**Consultation Response from KC,
Highways Development Management**
2020/90702 adj, 12, Rose Mount, Birkby, Huddersfield, HD2 2BU
Erection of detached dwelling
Date Responded: 23-03-2020
Responding Officer: Mark Berry
Responding Ref: 5-3SE-11

This application seeks approval to the erection of a 4 bedroomed detached dwelling at land adjacent to 12, Rose Mount, Birkby, Huddersfield.

Planning Drawing - Site Plan

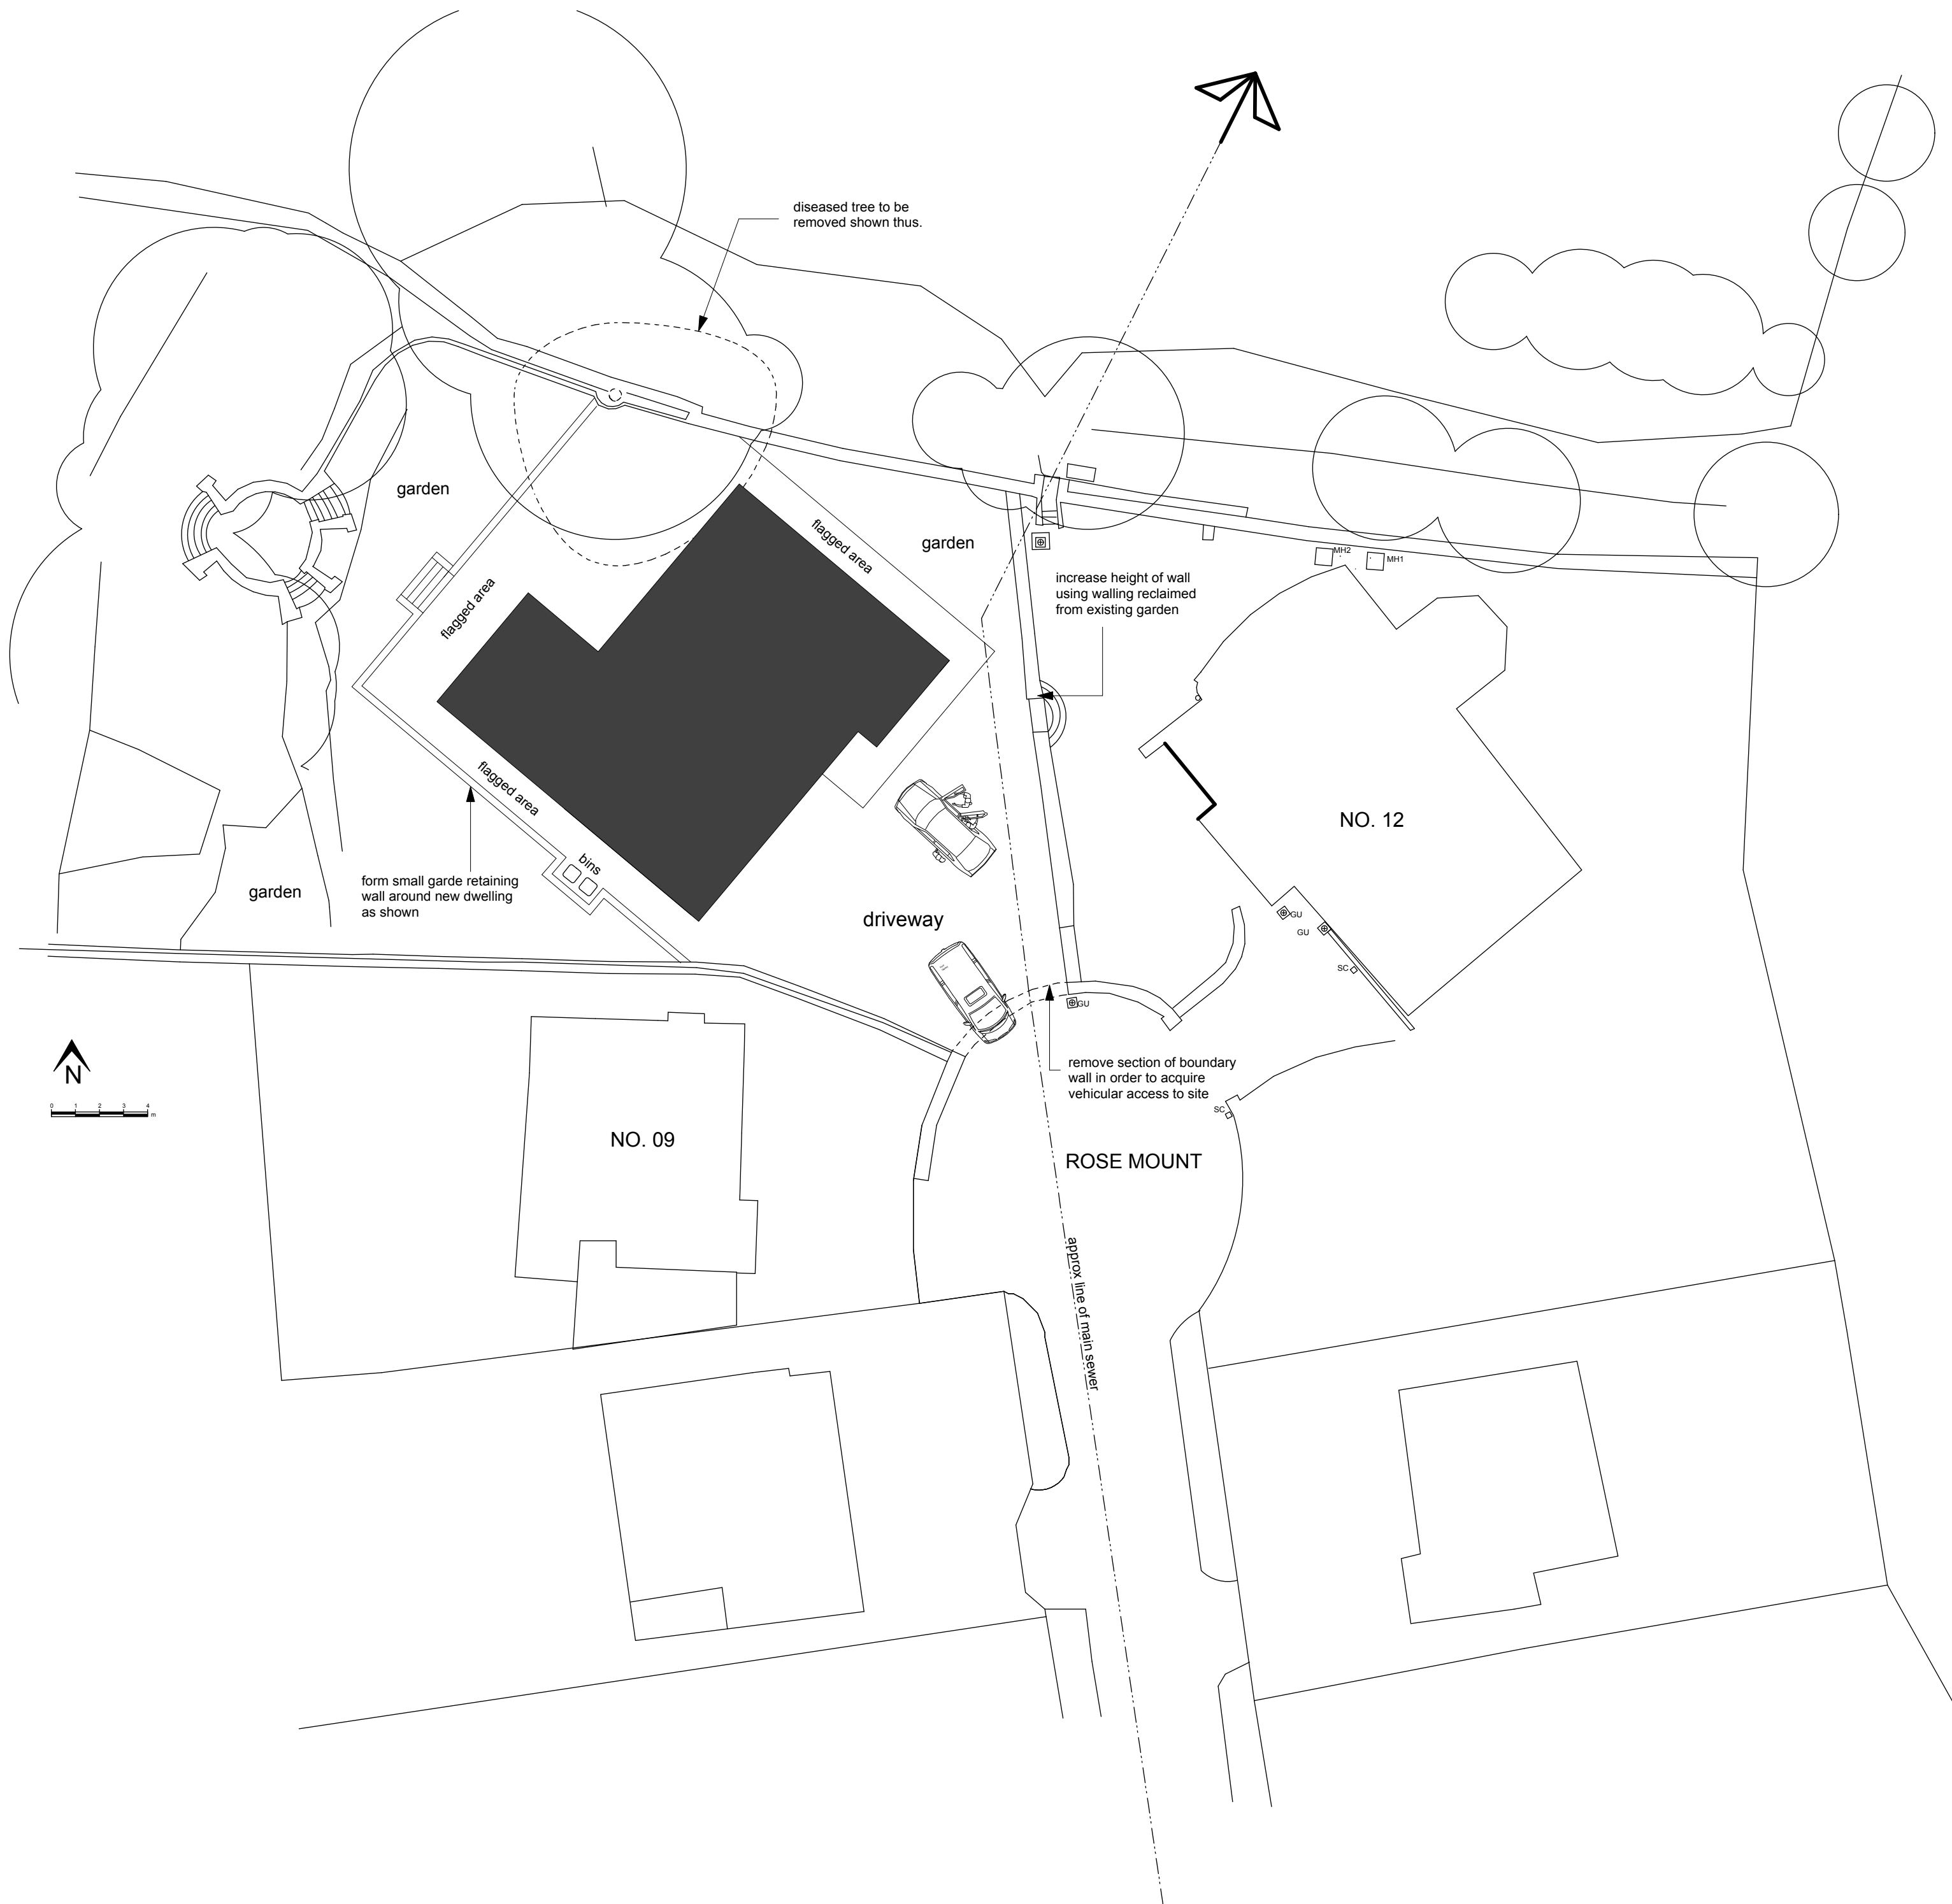
Access to the site from the existing turning head.

The plans show that the proposed dwelling will have a substantial single garage with a driveway to the frontage.

Given that sufficient off-street parking facilities are shown to be provided Highways Development Management have no objection to these proposals.

Areas to be surfaced and drained Prior to the development being brought into use, the approved vehicle parking areas shall be surfaced and drained in accordance with the Communities and Local Government; and Environment Agencies 'Guidance on the permeable surfacing of front gardens (parking areas)' published 13th May 2009 (ISBN 9781409804864) as amended or superseded; and thereafter retained throughout the lifetime of the development.
